House Type A1.

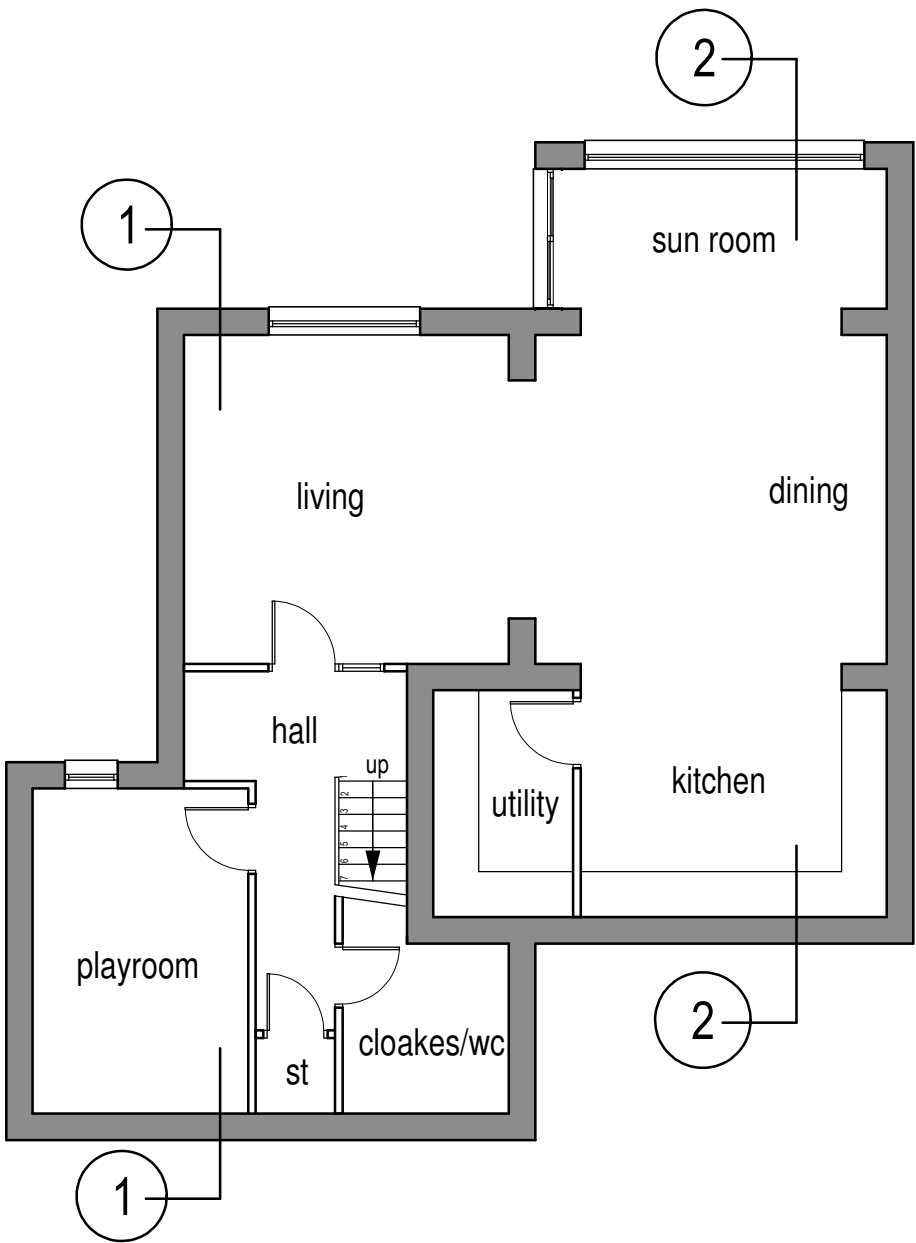
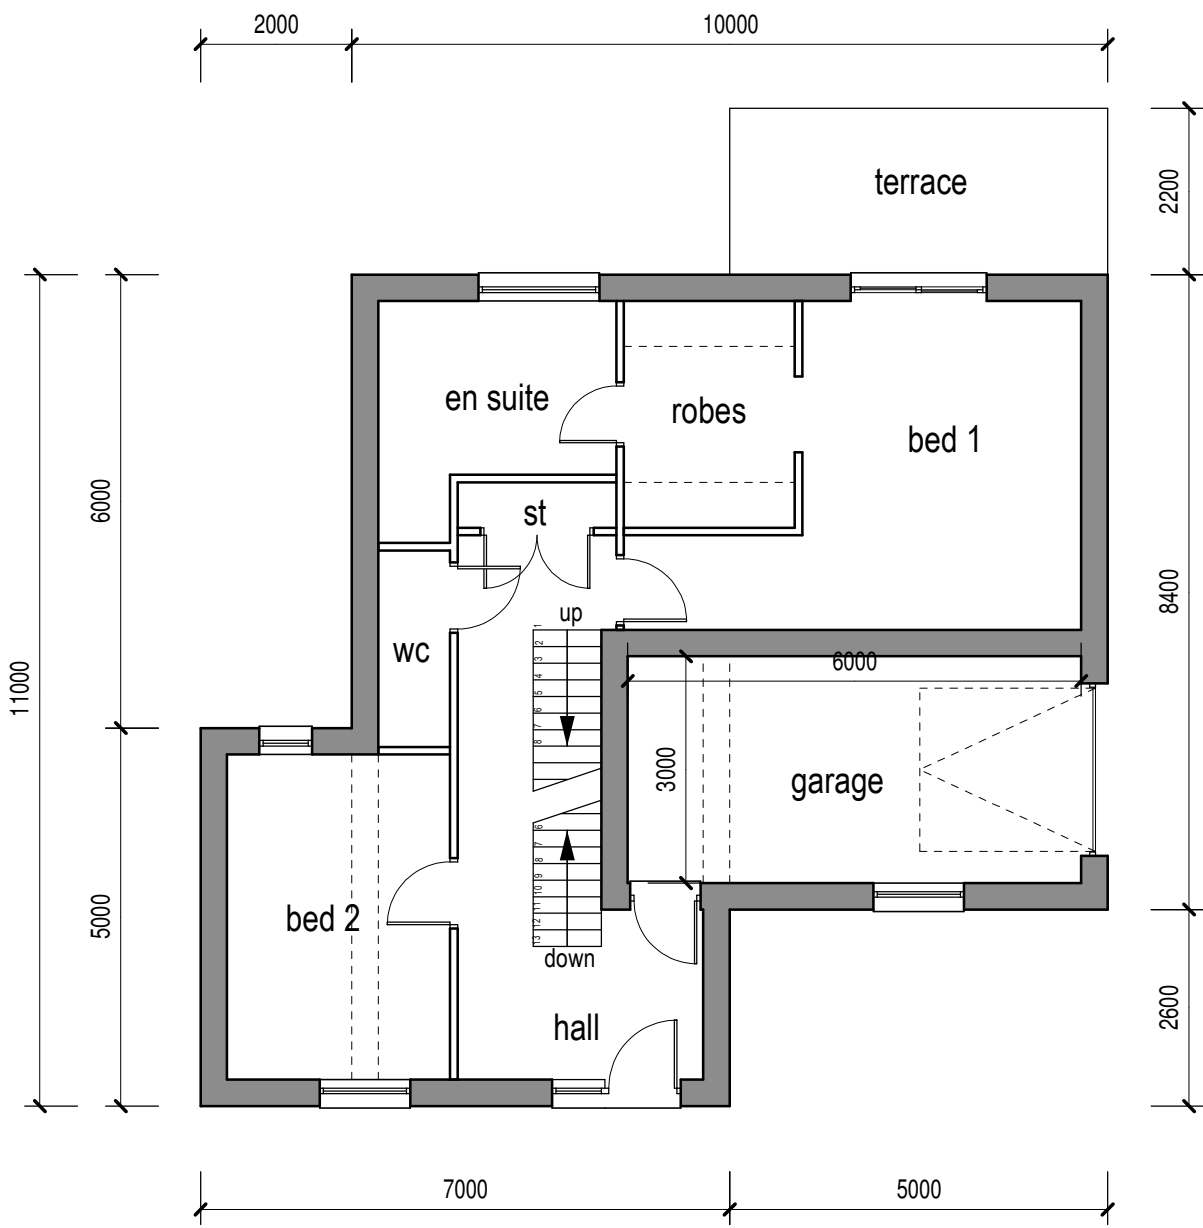
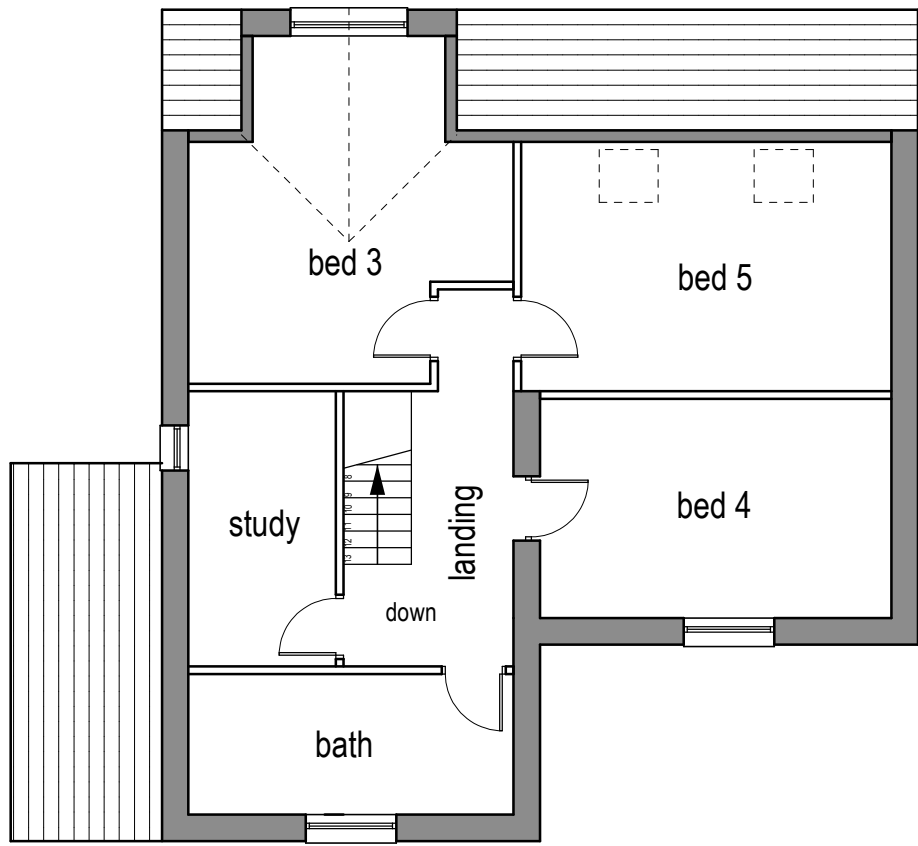
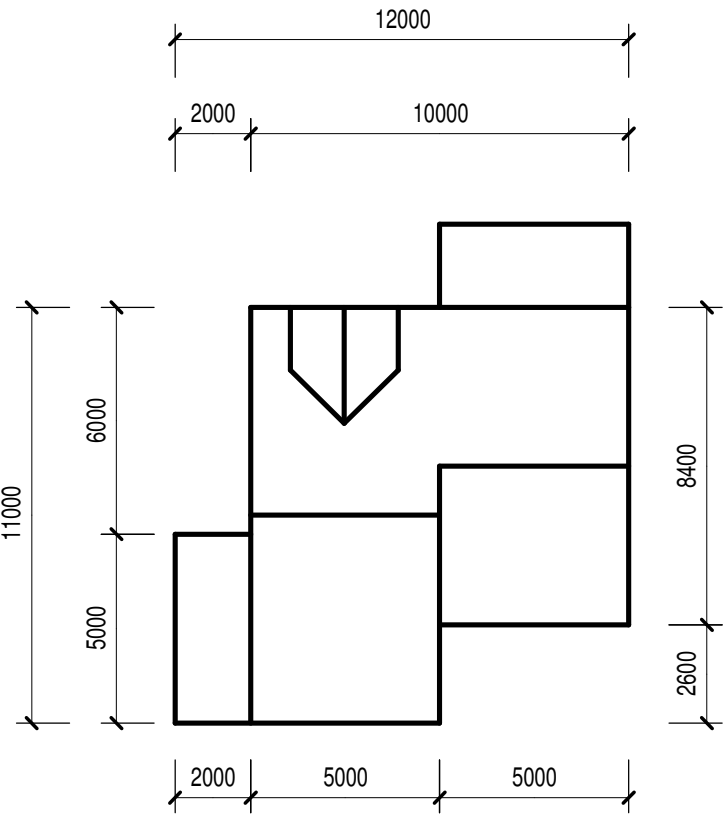
House type A1, for plots 34 and 35, would see residents enter on the middle floor. Fine for accessing a couple of bedrooms, but when the lounge and kitchen areas are downstairs, perhaps not ideal. Even the toilet, which is on the middle floor, is not ideal for a wheelchair user. At a width of 950mm, it is 550mm narrower than is recommended. And, if not taking bedroom 1, their bathroom is up on the next floor.
